6 November 2013

Name: Amanda Cobb
Address: 4 Calder
Rd Darlington
2008.

**Modification Request for the University of Sydney Abercrombie Precinct
Redevelopment: Application Number: MP07_0158 MOD 3**

Title
Scale
Date
Number
0 2 4
10 20m
Ground Floor Plan
MARK UP SET
1:200@A1
11.10.13
4001_DA02-D
© copyright nettleton tribe partnership pty ltd

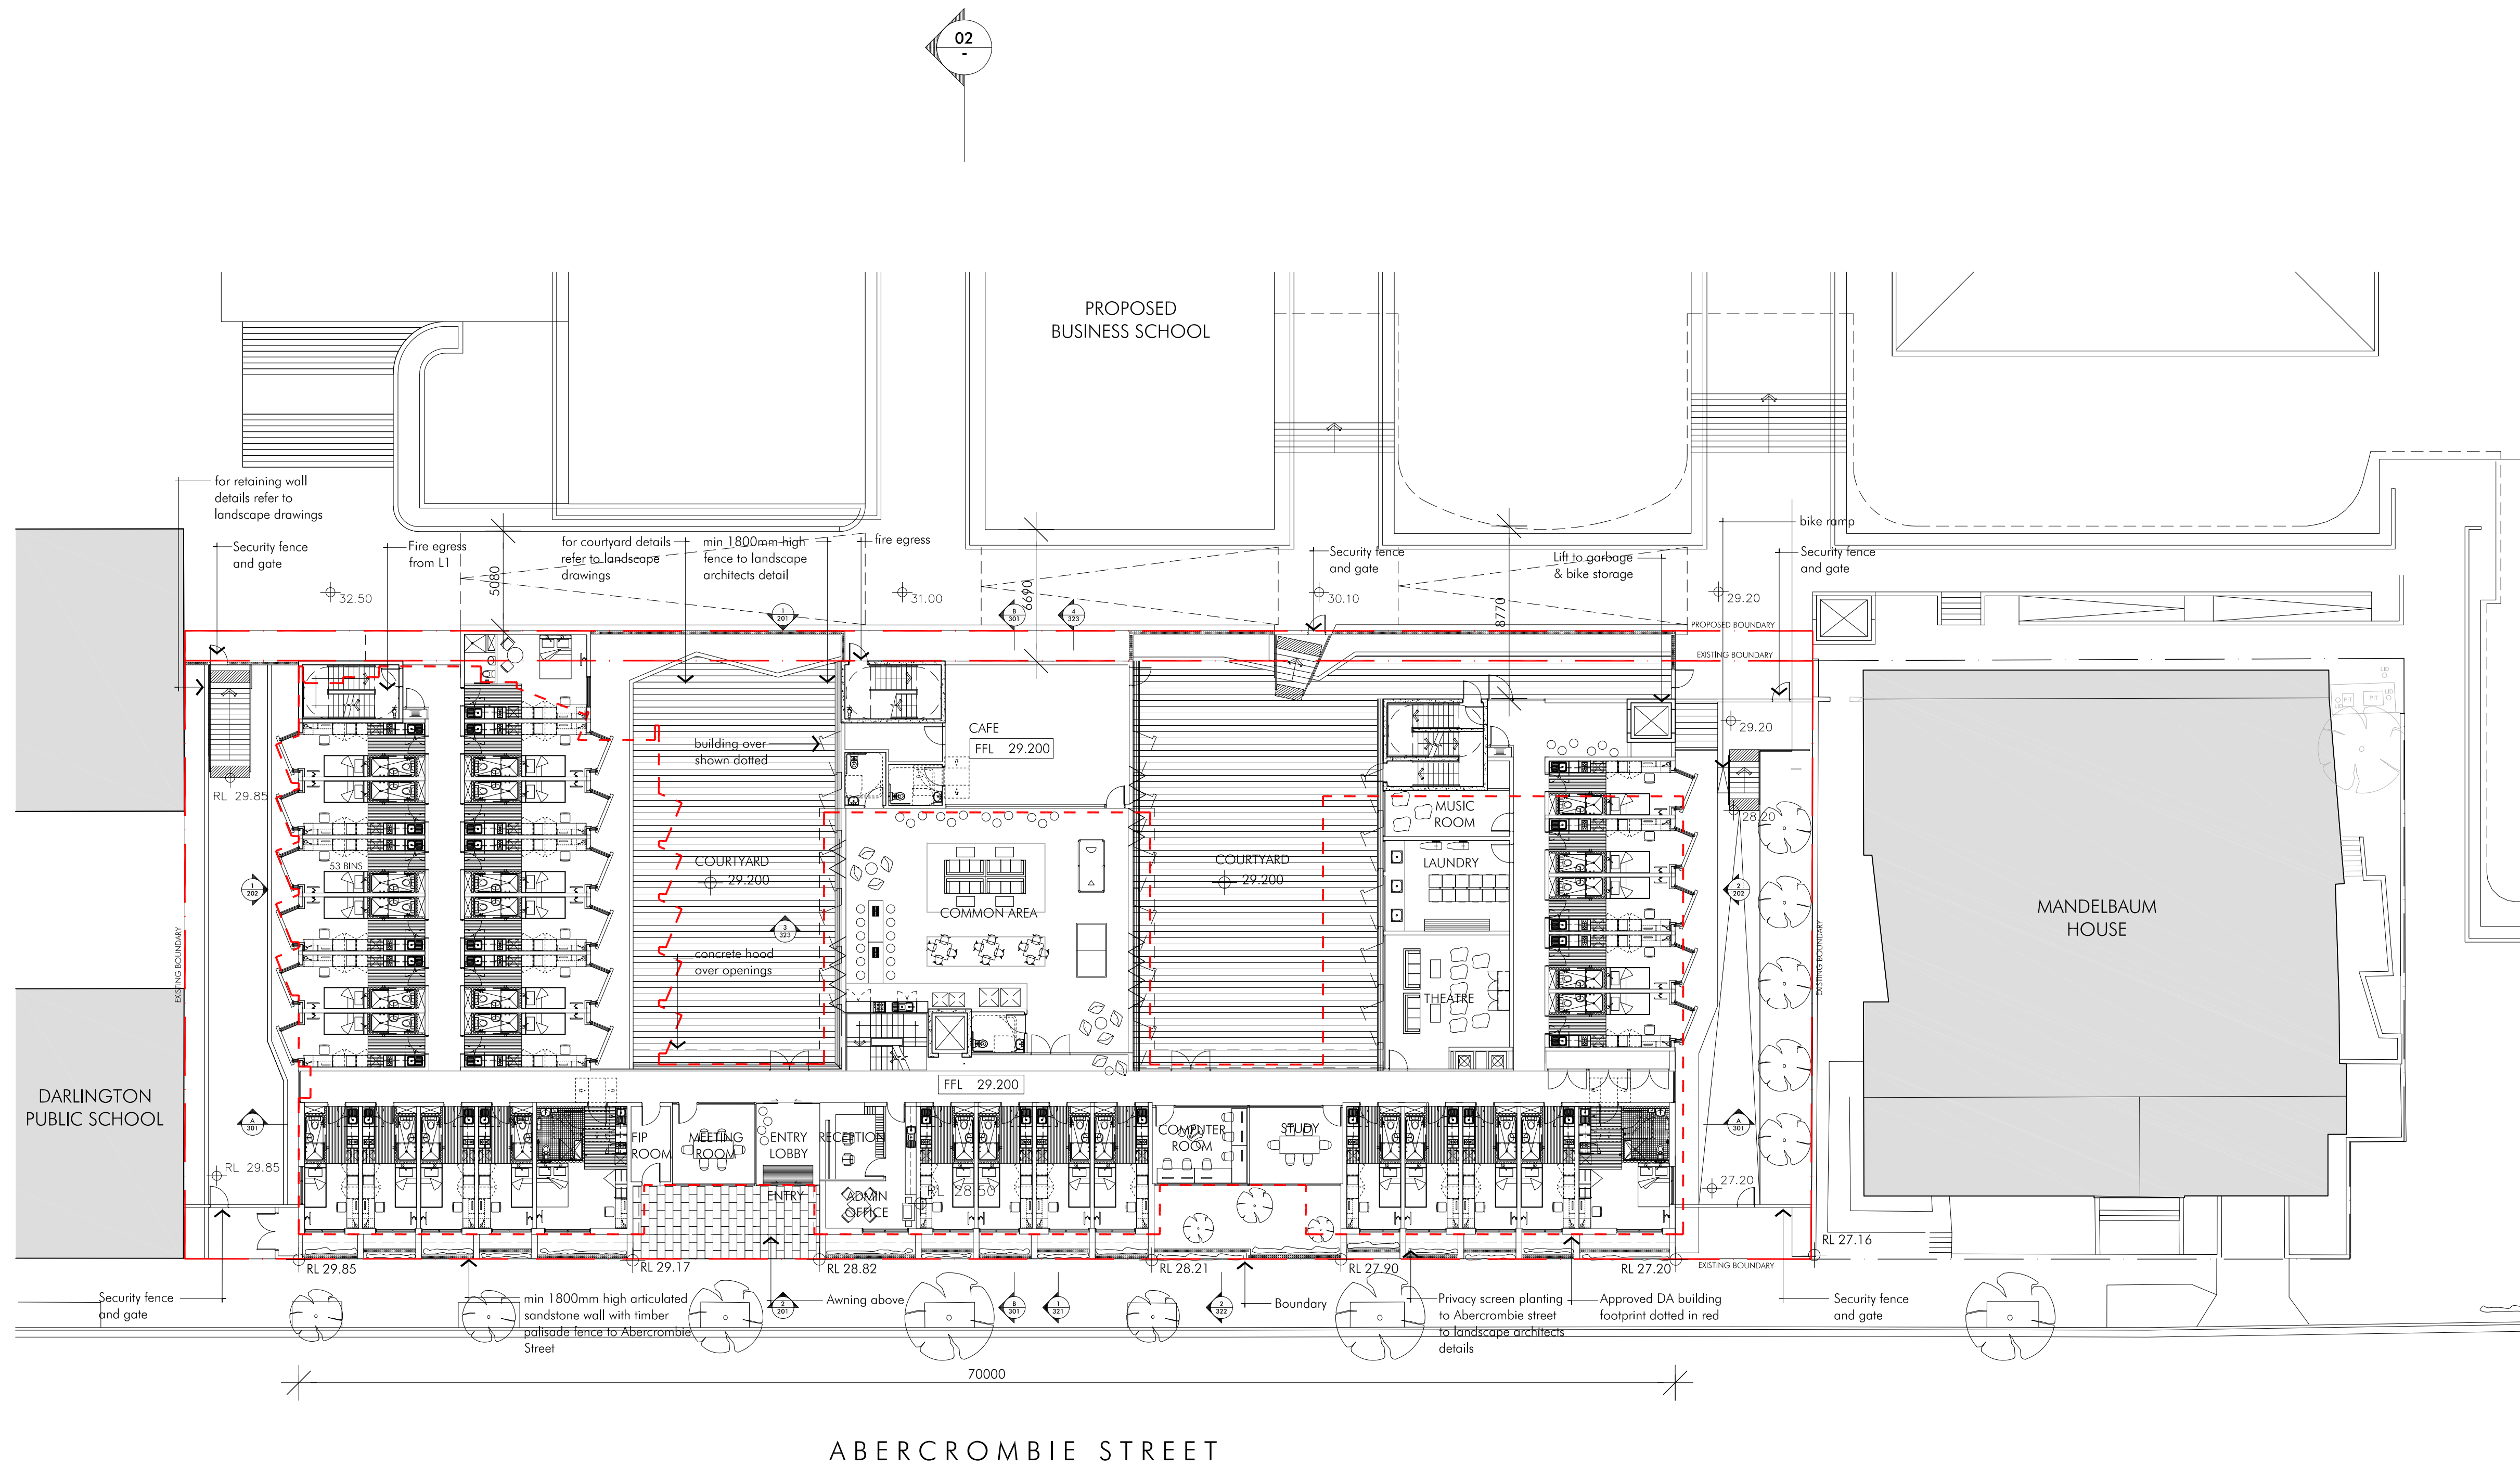
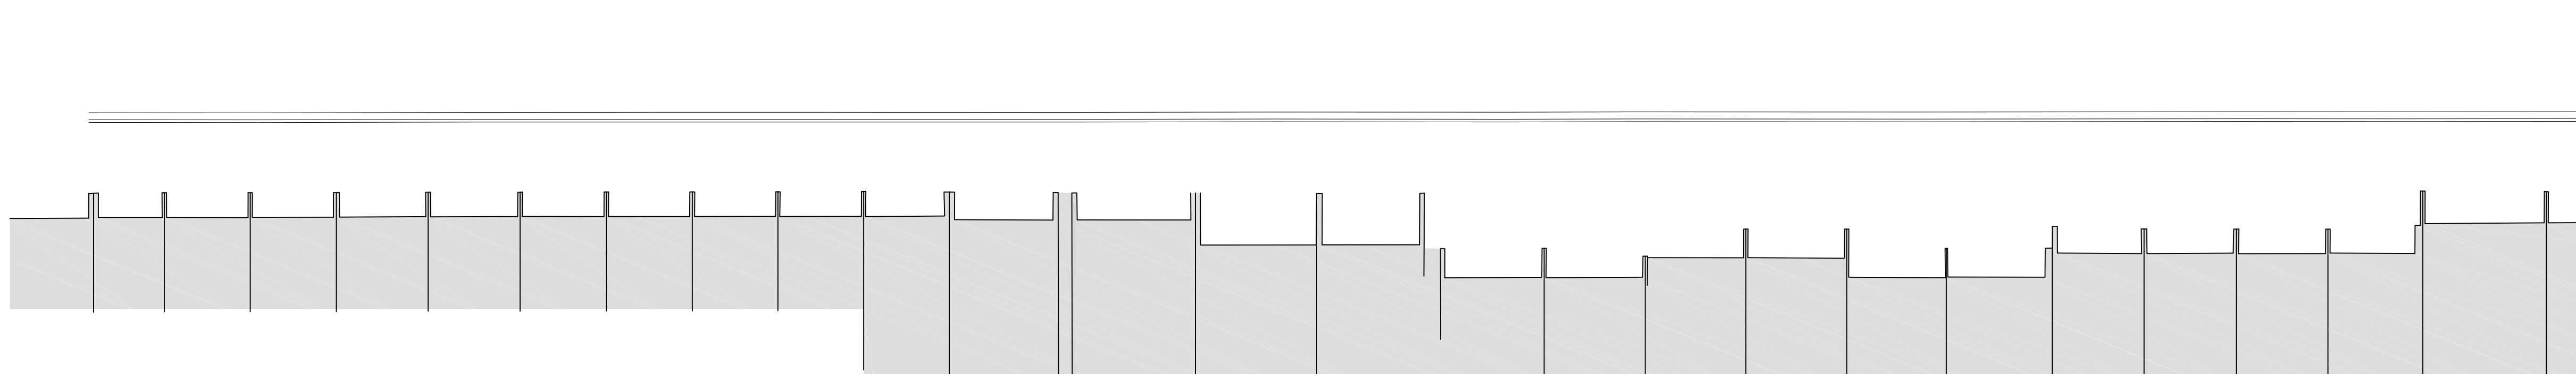
- The front of the Student Accommodation building should be built 2 metres back from the Abercrombie Street boundary. It should be set back from this boundary so that it is in line with Mandelbaum House as it was originally planned and presented to the community. The footprint of the buildings currently on the site, The Shepherd Centre and Boundary Lane Children's Centre, were built approximately 2 metres back from the Abercrombie Street boundary and align with Mandelbaum house. Therefore, the front footprint of the proposed Student Accommodation building should be the same as those buildings occupying the site at present and not be built up to the Abercrombie street boundary.

- The facade of the proposed Student Accommodation building does not reflect the heritage appearance of the Victorian terraces on Abercrombie Street as Mandelbaum House does. Therefore, it should be set back to allow for extensive vegetation and trees to be planted in front of the building on Abercrombie Street to help preserve the heritage streetscape and improve both the aesthetics and the environment of the street.
